Planning Application Reference No.: 3/2023/0707

Address of Development: 1 Lower Lane
Longridge
PR3 3SL

Proposal: Application to regularise mixed building use permitting retail with associated bar serving alcohol, and occupational dwelling (sui generis).

Existing and Proposed Ground Floor Plan

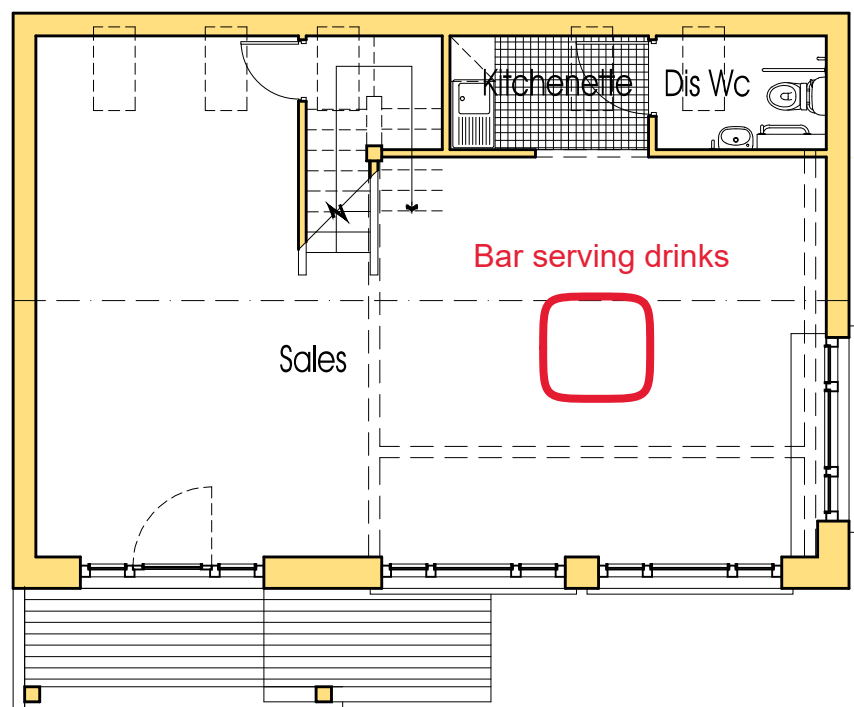
- It should be understood that the plan submitted with the application gives a false representation as to how the building is utilised. The plan shows the building split in to two distinct areas, bar and sales but in reality, it is both areas used by drinkers and when entertainment is on there are also customers singing and dancing, influenced by alcohol.
